**KIRKLEES METROPOLITAN COUNCIL
INVESTMENT & REGENERATION SERVICE**

Reference No:	2025/62/90778/W
Site Address:	land at, Albert Street Car Park, Albert Street, Lockwood, Huddersfield, HD1 3PR
Description:	Erection of two storey commercial unit
Recommending Officer:	Kerri Simpson

DECISION – REFUSED

Officer Report – 2025/90778

PROPOSED ELEVATIONS AND FLOOR PLANS	
ALBERT STREET CAR PARK, HUDDERSFIELD, HD1 3PR	
SCALE: 1:100 (ISO A2)	ALL DIMENSIONS IN MM
DATE: 19-03-25	PP/19325/2 Issue 1
PROPOSED SCHEME	2 OF 2

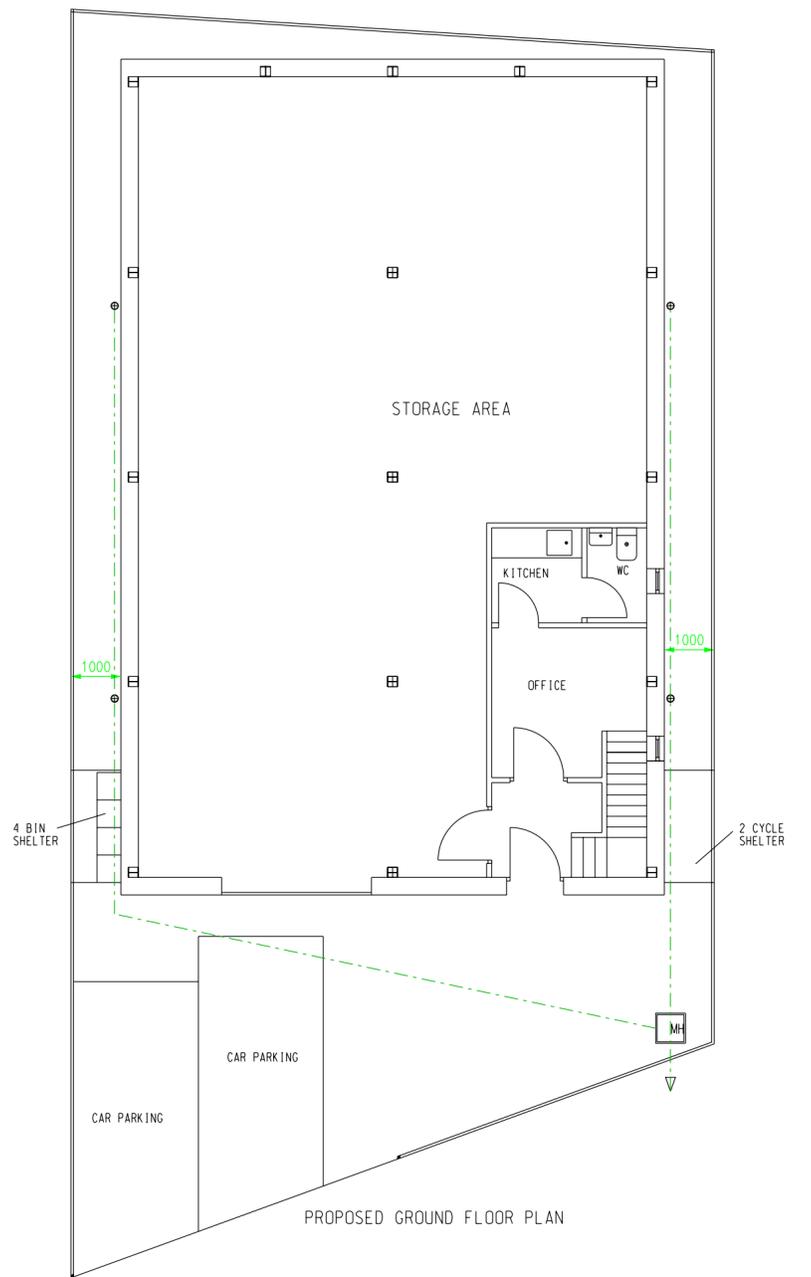
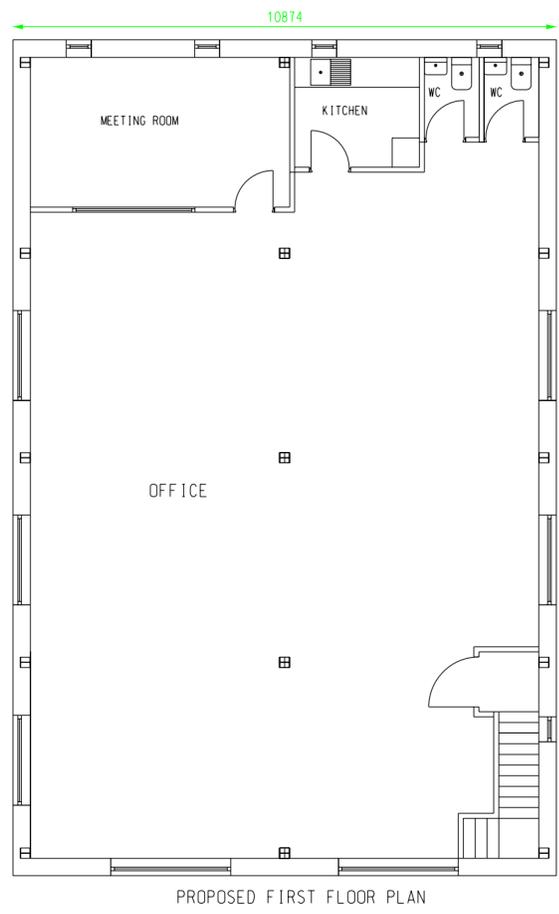
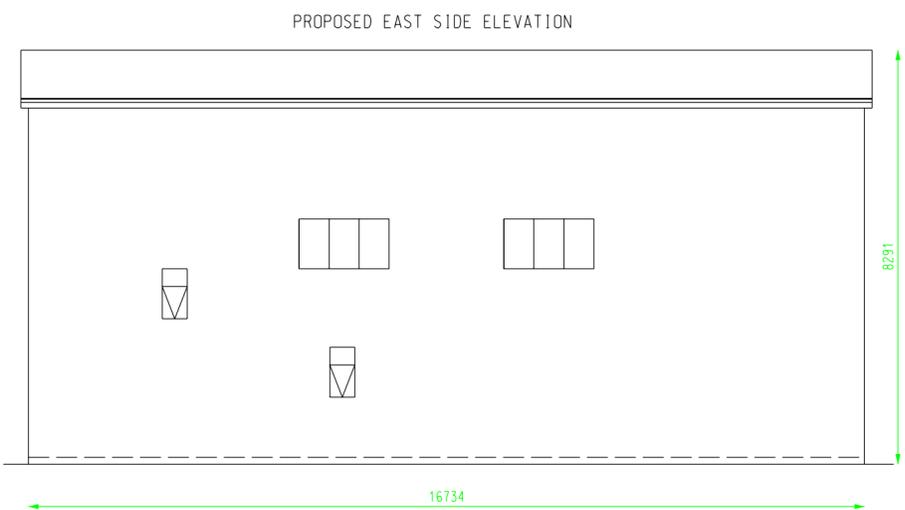
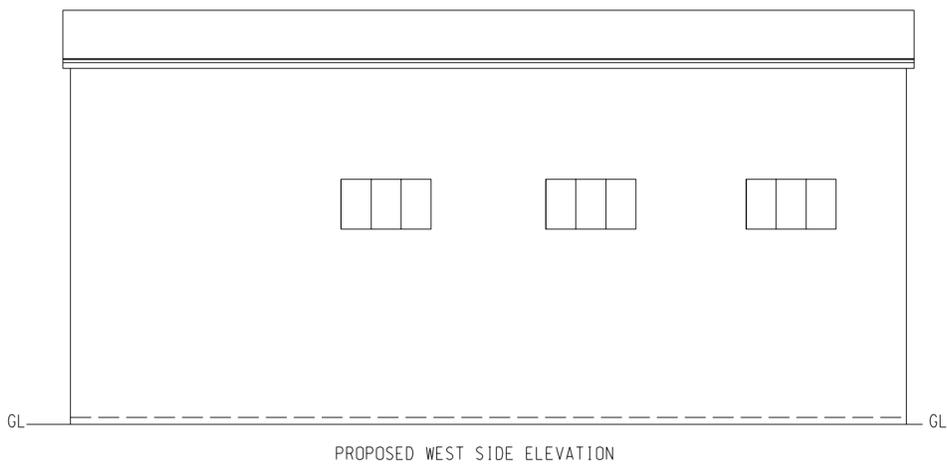
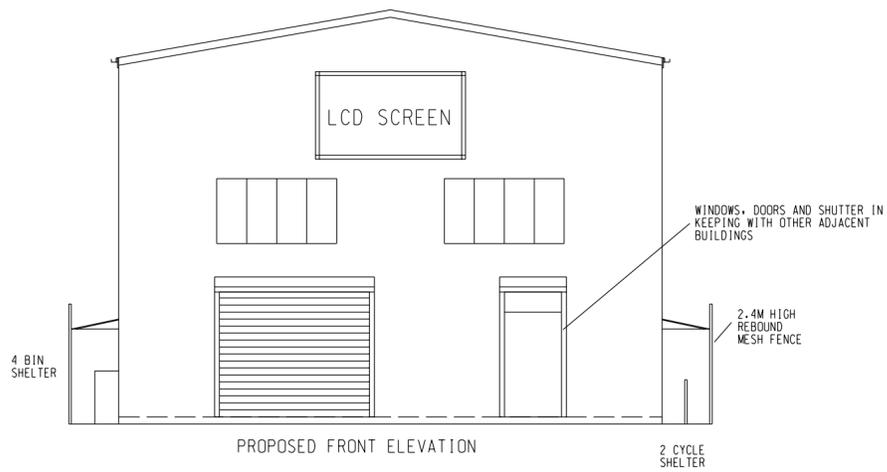
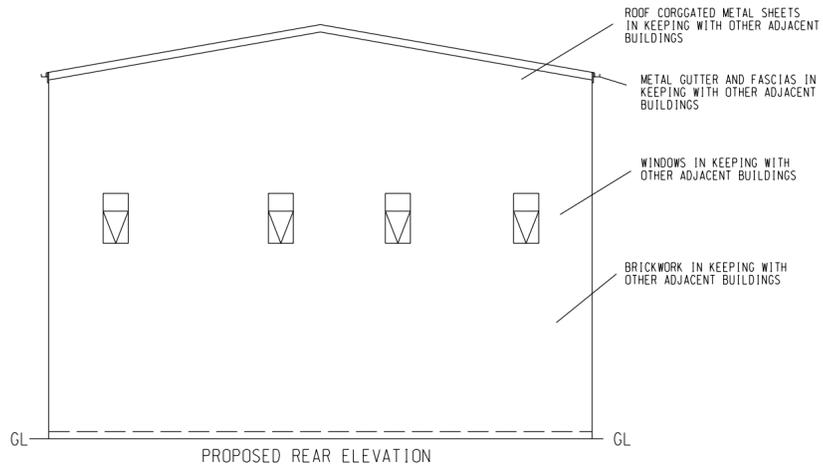
The application proposes a two-storey commercial building comprising circa 163sqm of storage and distribution (Use Class B8) at ground floor level together with office accommodation at first floor level. The site would be served by two off-street parking spaces located to the front of the building with direct access onto Albert Street.

The application site is located within an established Priority Employment Area, which is commercial in nature and where on-street parking is already prevalent and limited. The submitted layout does not demonstrate any dedicated servicing arrangements or service vehicles associated with the proposed use.

inadequate for the scale and nature of the proposed development and that insufficient information has been submitted regarding servicing and maneuvering arrangements. In particular, concerns are raised that vehicles would be required to reverse onto/from Albert Street due to the constrained nature of the site and absence of turning facilities, which would be prejudicial to highway safety.

Whilst the site lies within a commercial area, the proposal represents an intensified form of development on a constrained plot without adequate provision for parking, servicing or safe vehicle maneuvering. These concerns are considered fundamental to the layout and operation of the development and cannot be satisfactorily addressed through planning conditions.

Furthermore, the proposal has failed to demonstrate adequate parking, servicing and vehicle manoeuvring arrangements, resulting in unacceptable impact on highway safety, contrary to Policies LP21 and LP22 of the Kirklees Local Plan and Chapter 9 of the National Planning Policy Framework 2024.
